CITY OF PORTLAND, MAINE

Project Name: Jewish Community Center and Preschool/Daycare
Conditional Use and Level III Site Plan

Project #: #2015-058 (Conditional Use and Site Plan)

On July 14th, 2015, the Planning Board considered the Conditional Use and Site Plan application for the construction of a neighborhood center (defined as a "Place of Assembly") and preschool/daycare on the site of the existing St. Patrick's Catholic Church at 1342 Congress Street. The project includes demolition of the existing church (14,960 sq. ft.) and construction of a single story 19,300 sq ft building on a site of 91,126 sq feet. The Planning Board reviewed the proposal for conformance with the standards of the Conditional Use Review and Site Plan Ordinance, and approved the application with the following waivers and conditions as presented below.

C-2B

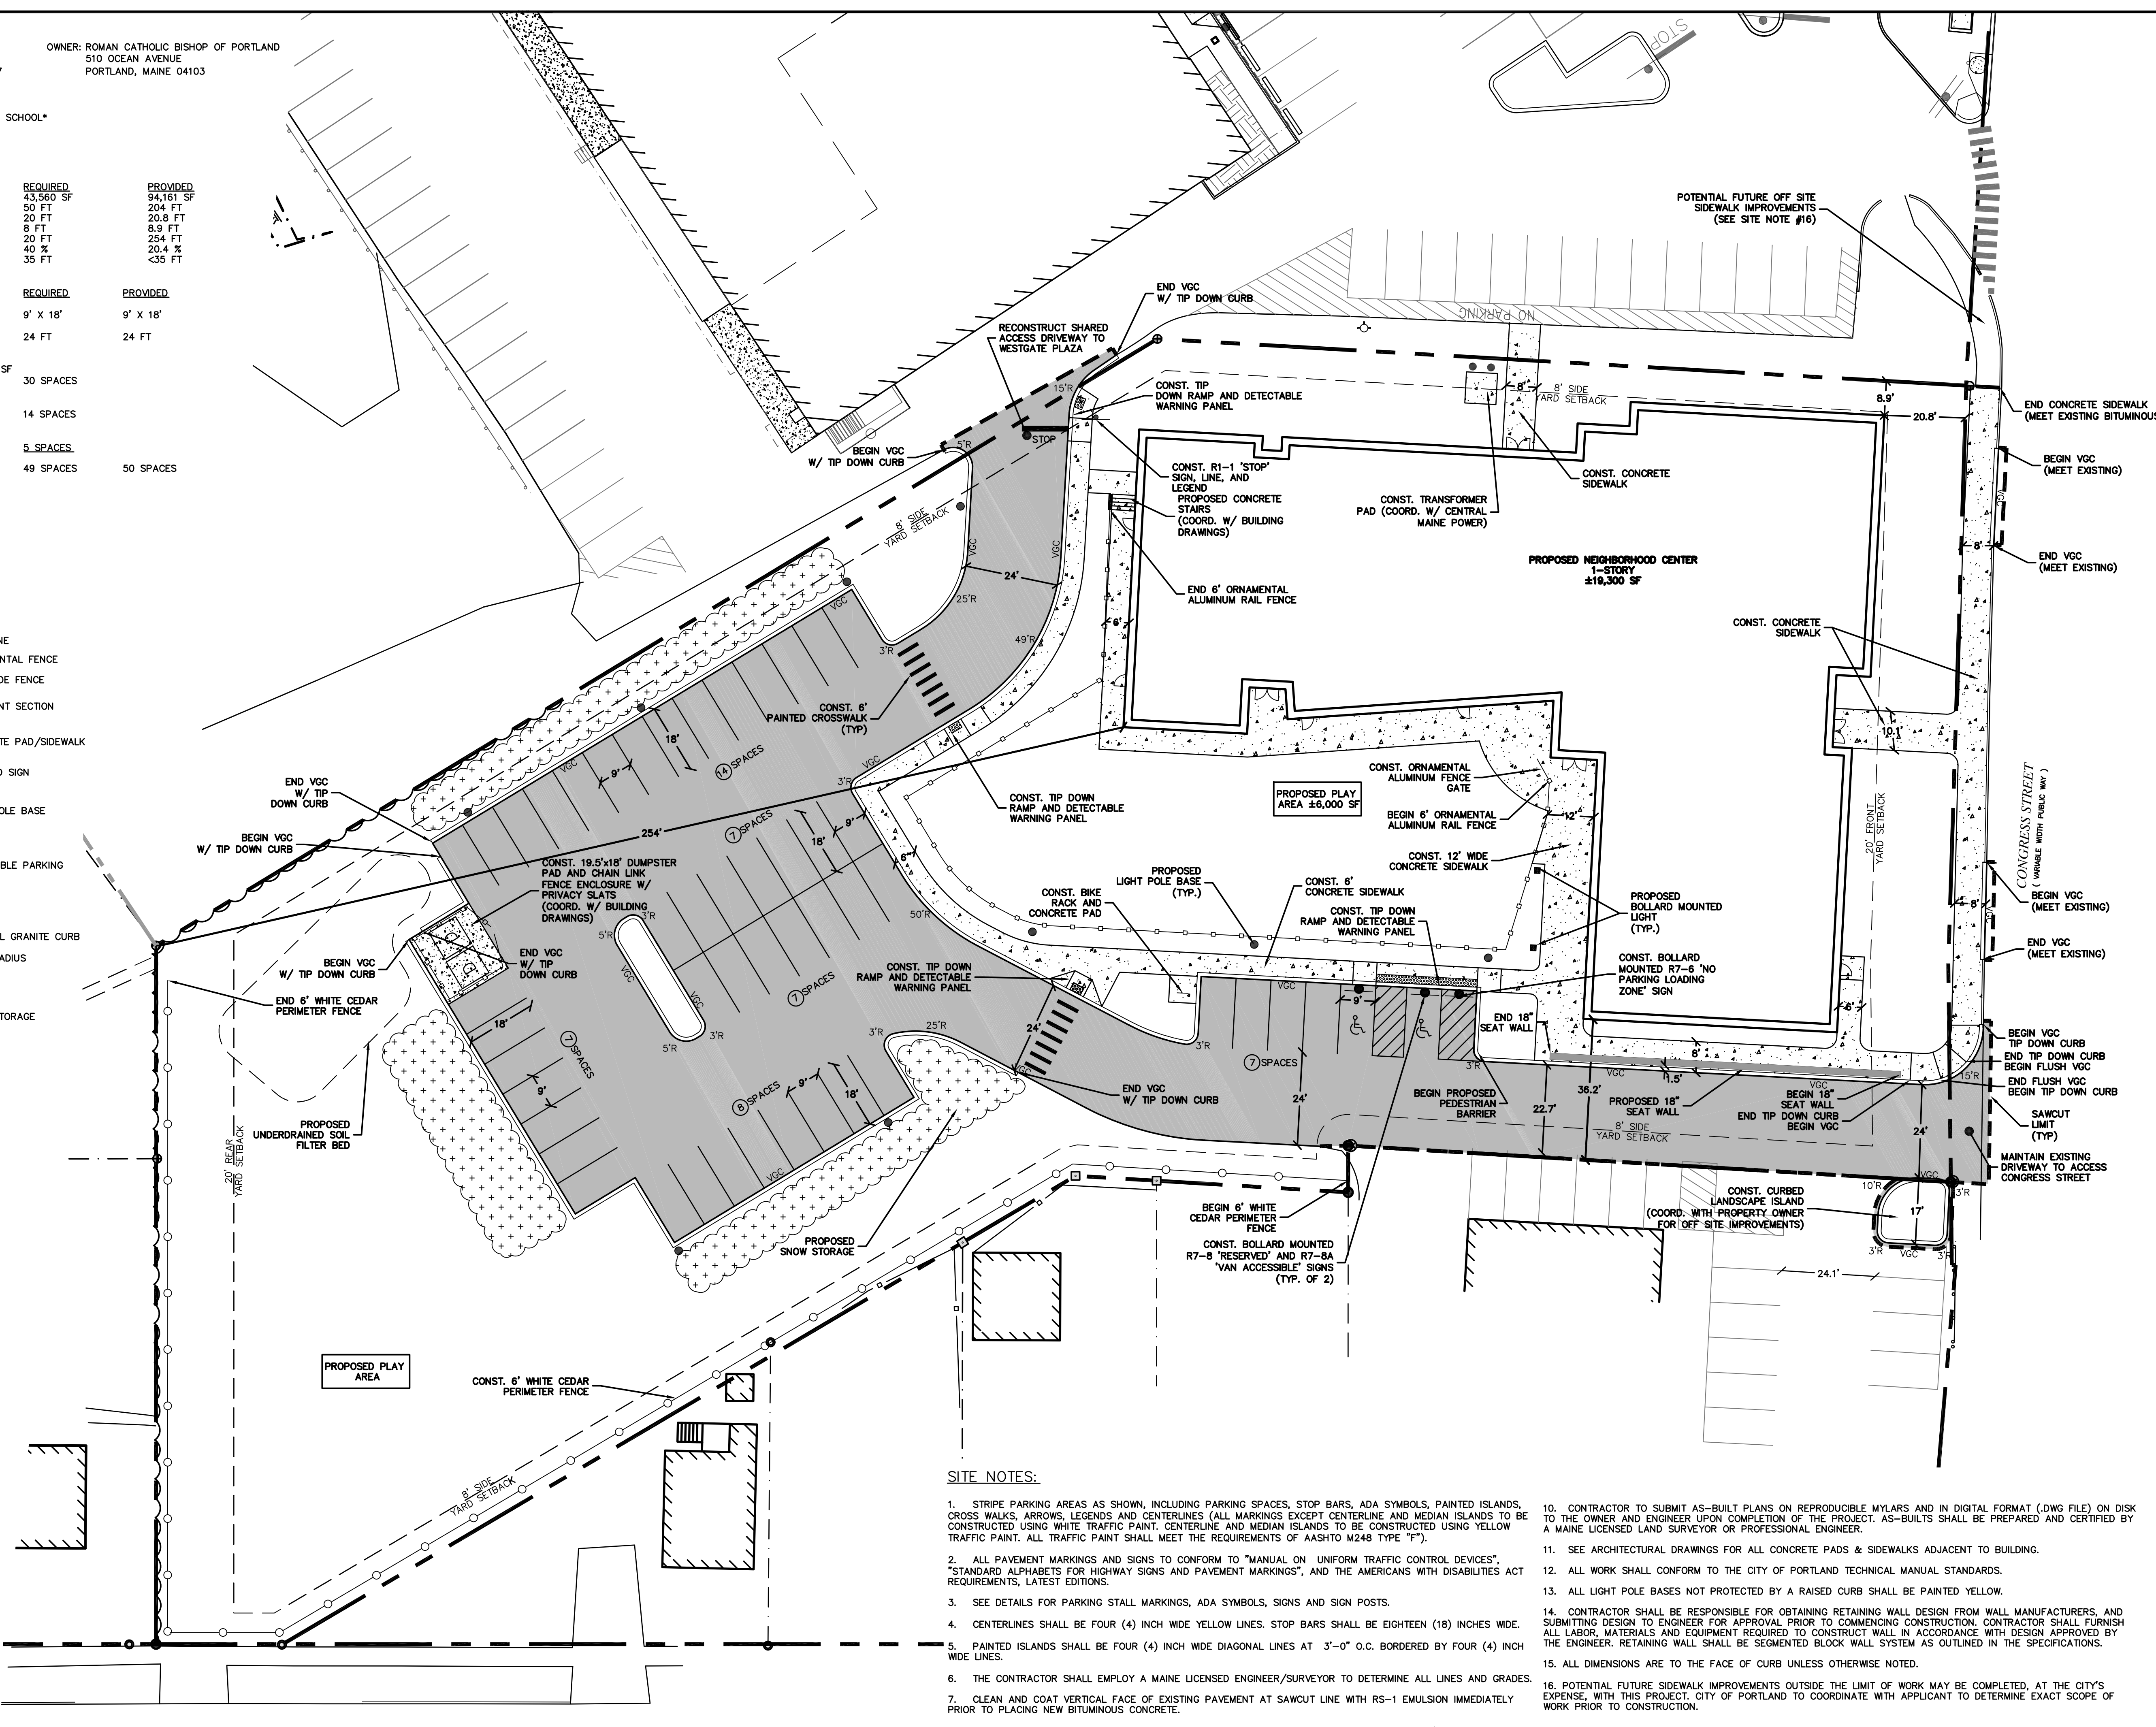
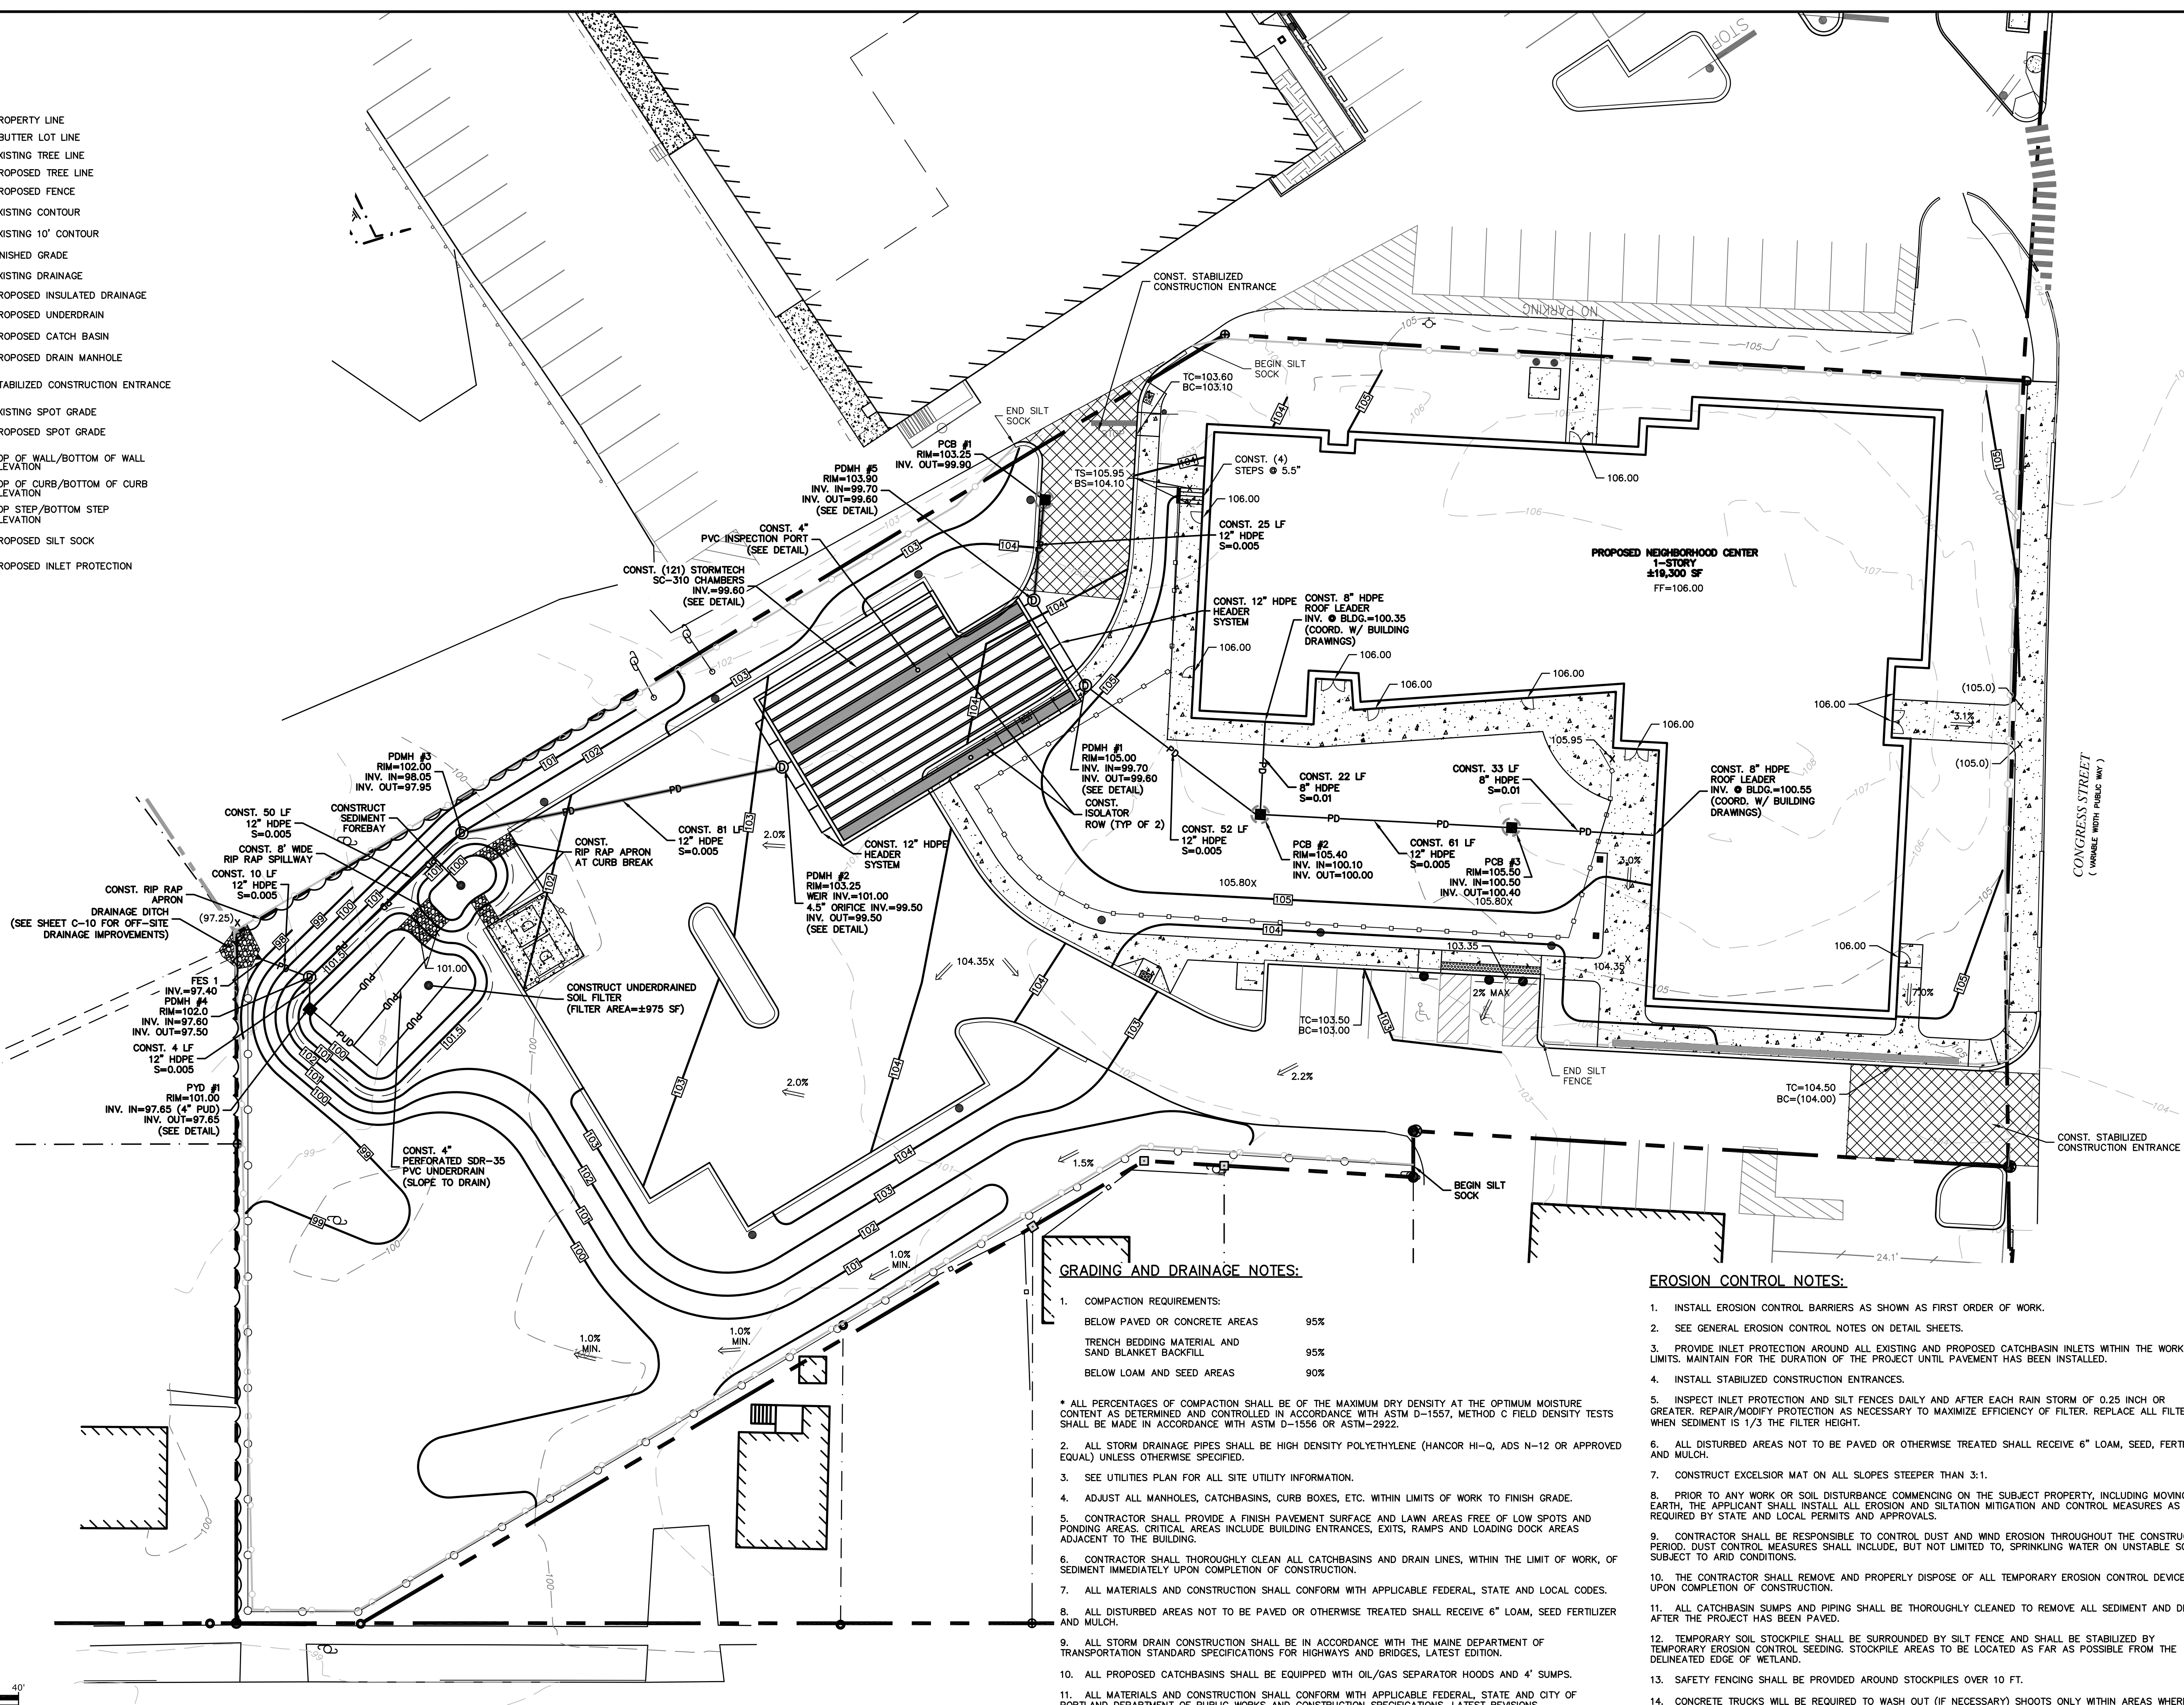
The Planning Board voted 6-0 (Morrissette absent) to waive Technical Design Standard Section 1.7.1.3 to allow the proposed driveway to be 22.7 feet wide for one section near Congress Street as shown on the Site Plan in Plan P6;

- iii. That the applicant revise the curb ramp layout at Congress Street in accordance with the comments of Tom Errico dated June 26, 2015, with revised plans to be reviewed and approved by the Planning

- The driveway entering the site from Congress Street is noted as having a width of 22.7 feet. This width (in the area where parking maneuvers occur) does not meet City standards and thus a formal waiver should be requested by the applicant.

Status: The curb ramp layout should be revised so that the ramp flare does not impact accessibility along the sidewalk route. Having a tip-down design will help to address this issue.

Status: I find the proposed driveway width to be acceptable given that most vehicles will be passenger cars and that a secondary driveway via the Westgate Shopping Center will be provided. I support this waiver request.
